Demolition of the existing garage building (B2 industrial use) and redevelopment of the site providing 9no C3 residential units - This application affects the character and appearance of River Road Conservation Area.

25 River Road Littlehampton

Thank you for your internet representation made on 20th June 2019 which has been recorded as '**an objection**' with the comments as follows:

LU/126/19/PL 25 River Road, Littlehampton

Proposed Drawings:
Terminus Place
Roof Plan

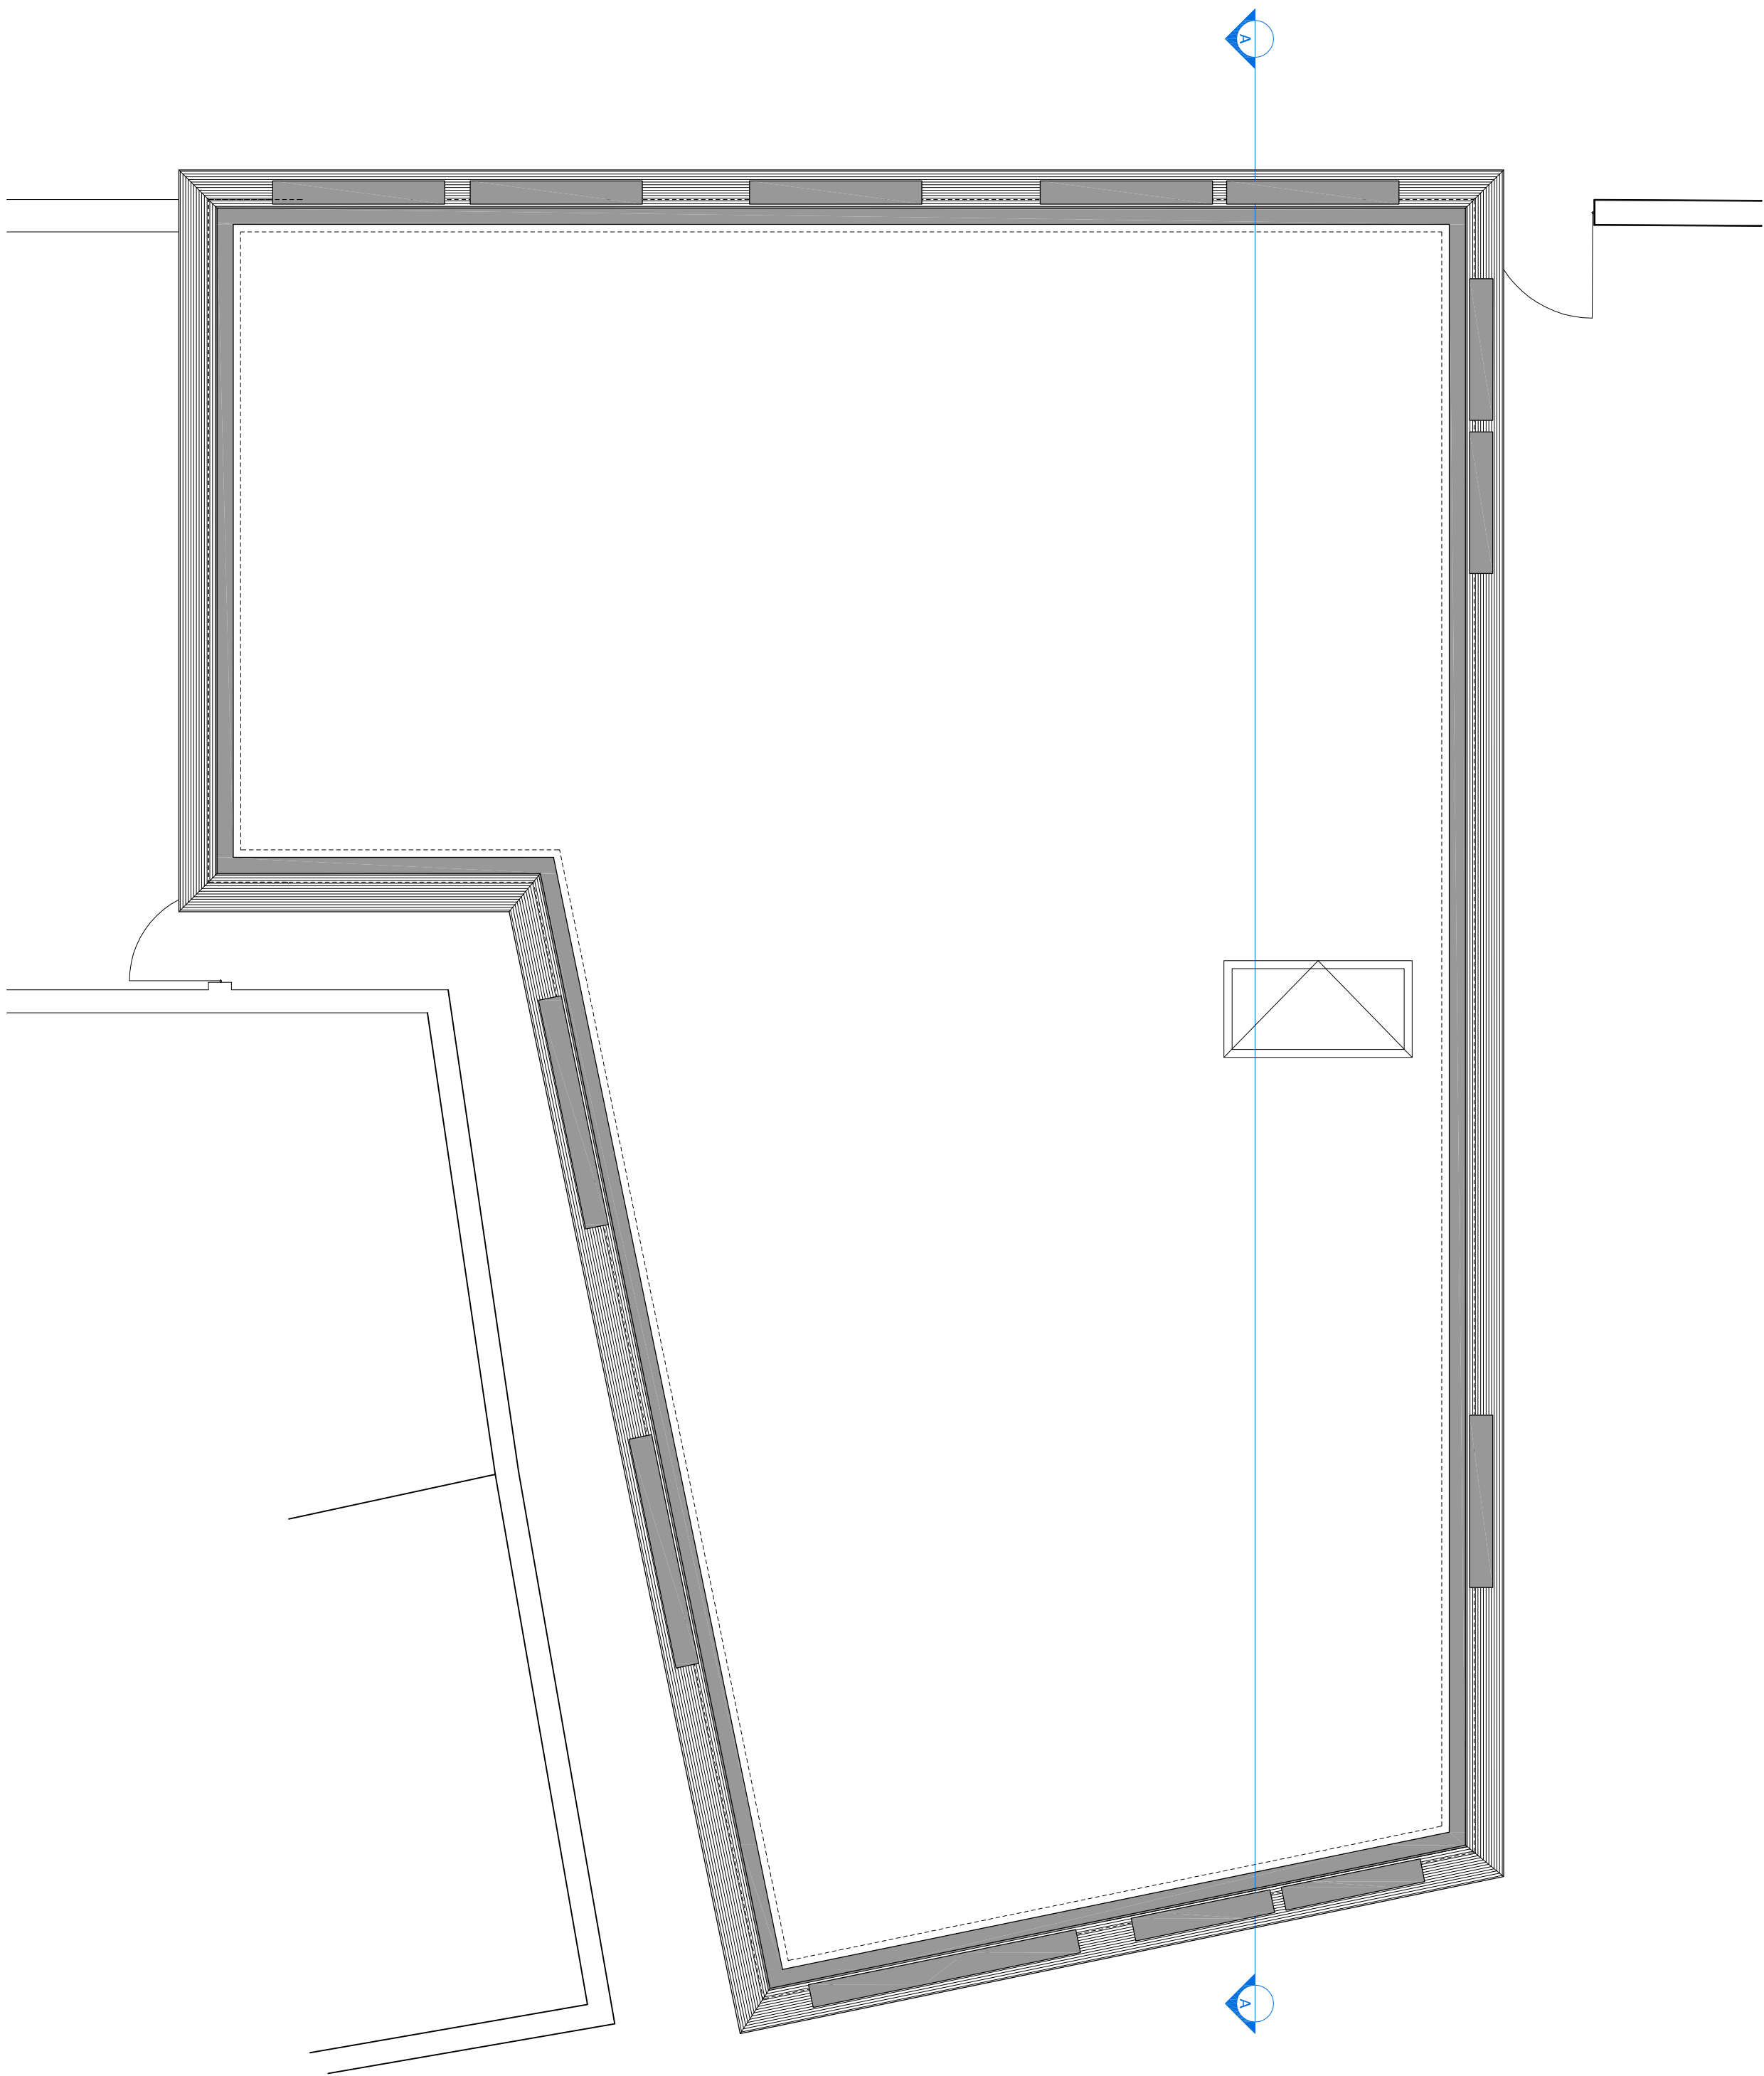
A Mansard roof is not appropriate in the Conservation Area where most of the properties are two storeys and have traditional roof shapes. The development should complement the houses on the eastern side of Terminus Place which is a terrace of two storey, small scale houses with traditional windows, doors and roofing. As proposed, the development would completely dominate and have a harmful effect on this terrace.

PROPOSED DRAWINGS:
Terminus Place
Proposed & Existing Street Scenes

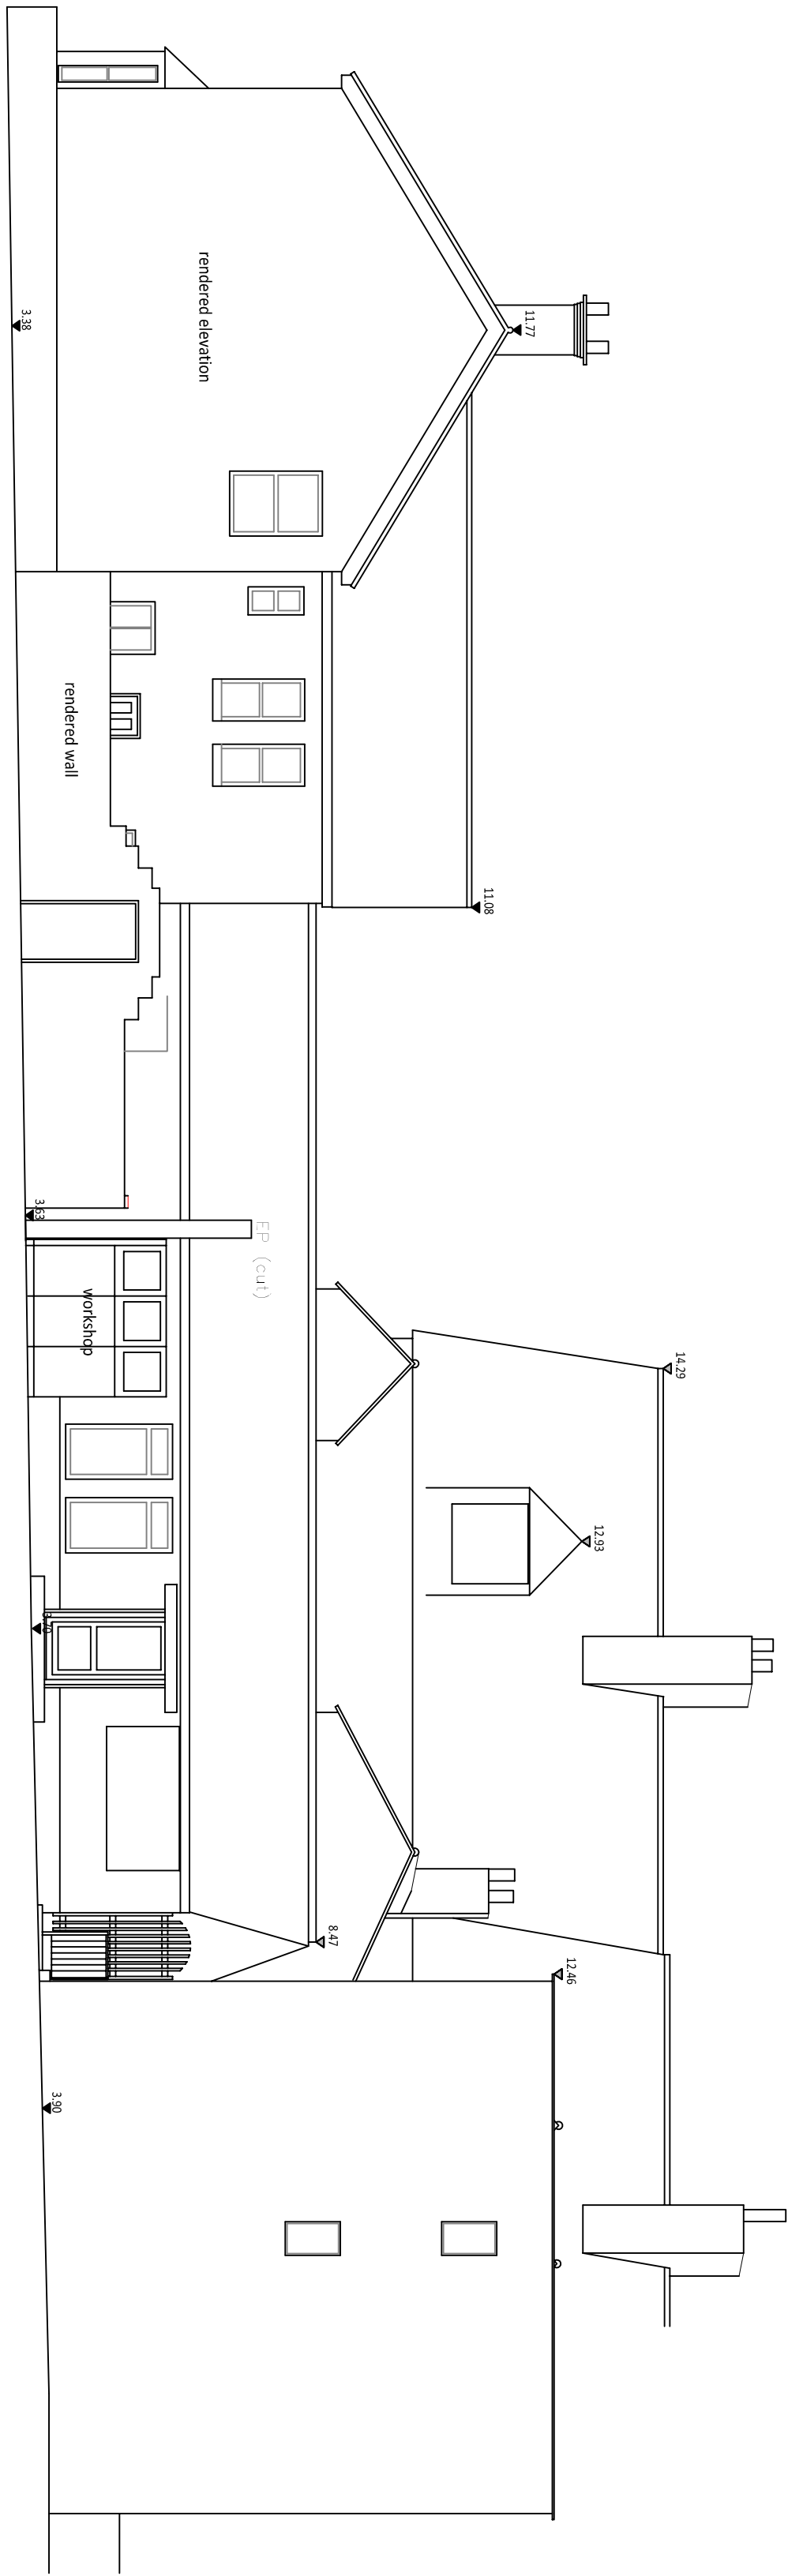
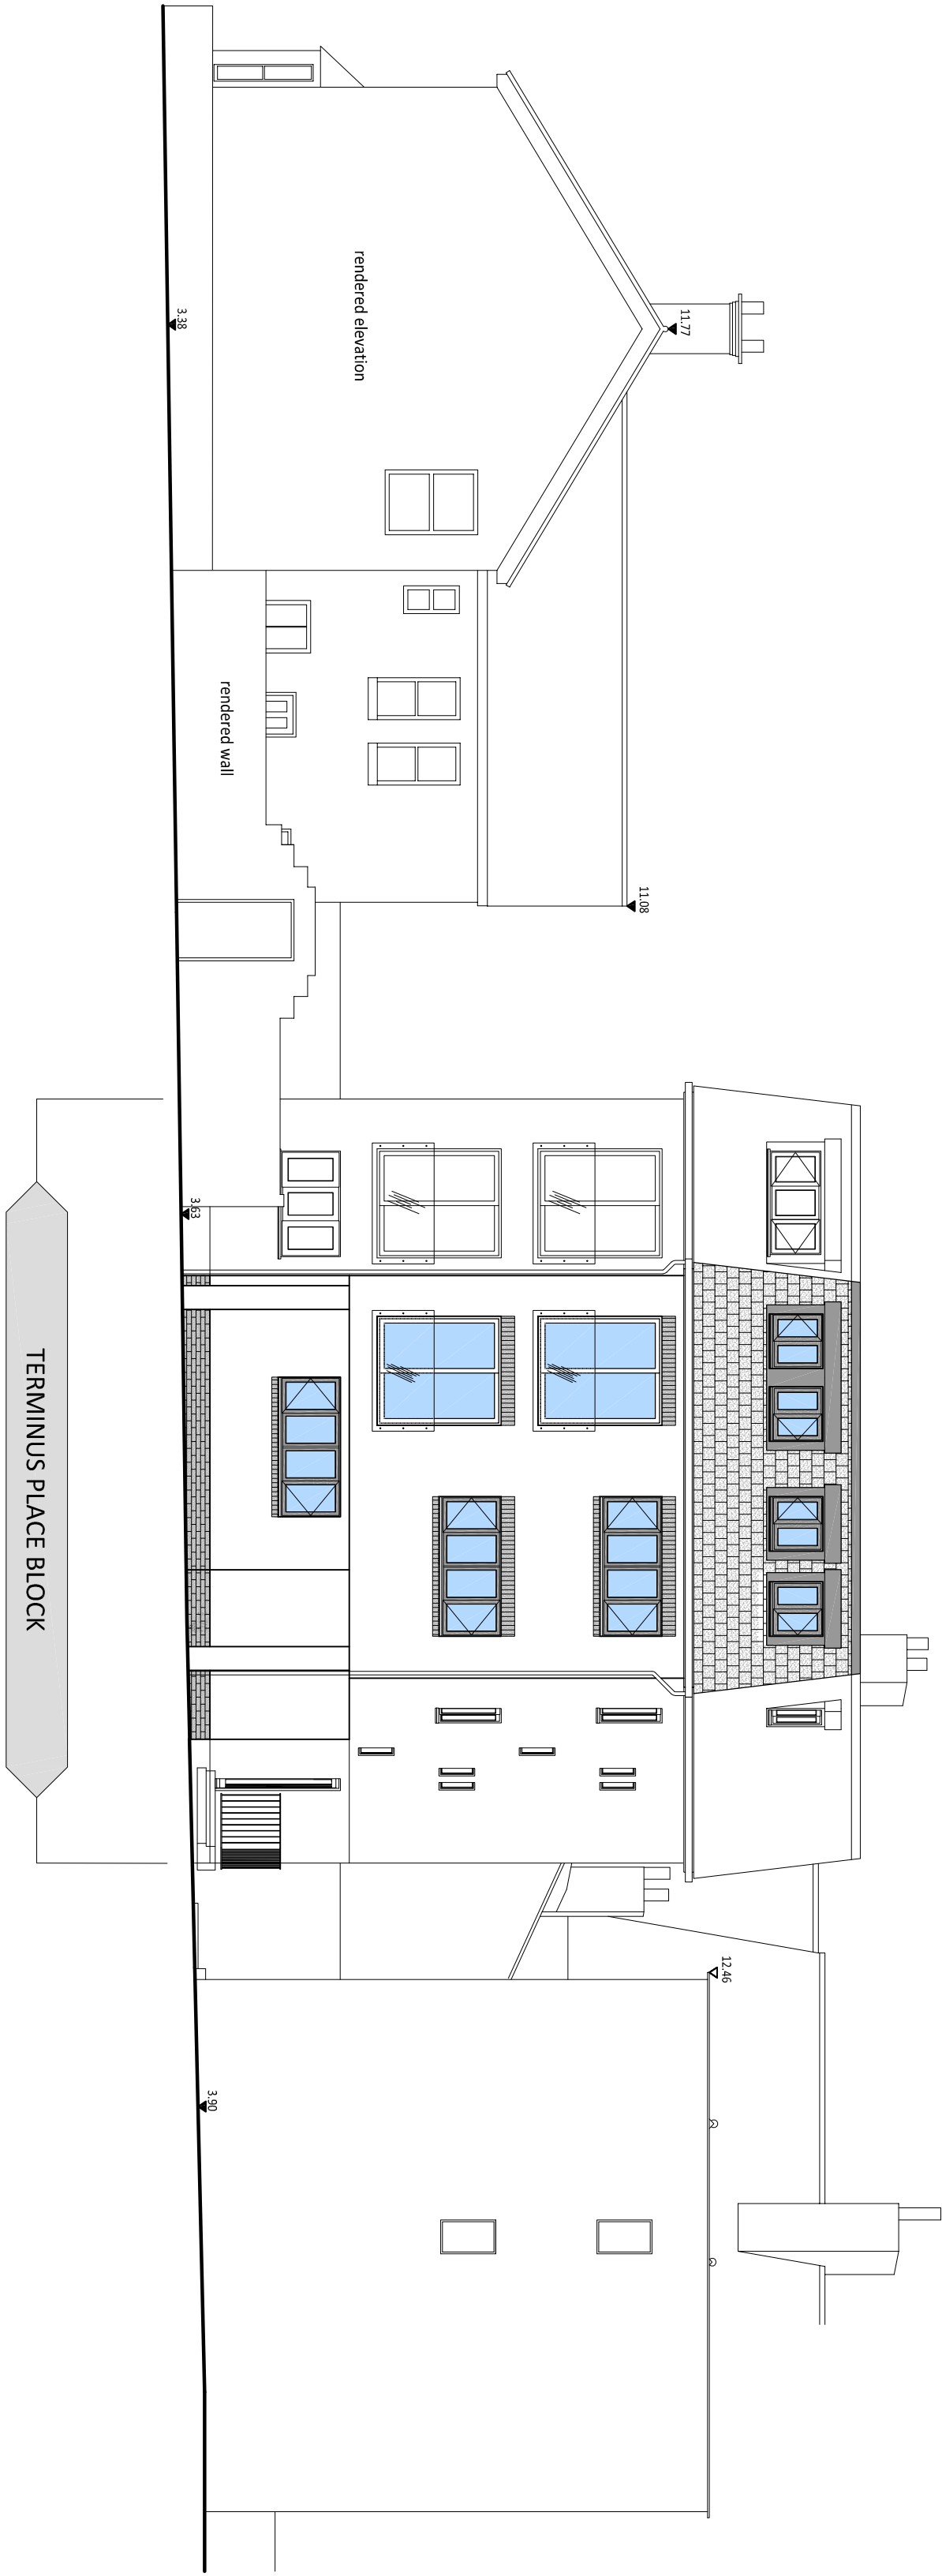
The proposed development is in the River Road Conservation Area and, as such, will have a harmful effect on it. It is overlarge, too high, too dense and far below the quality of form and design that should be expected for this site.
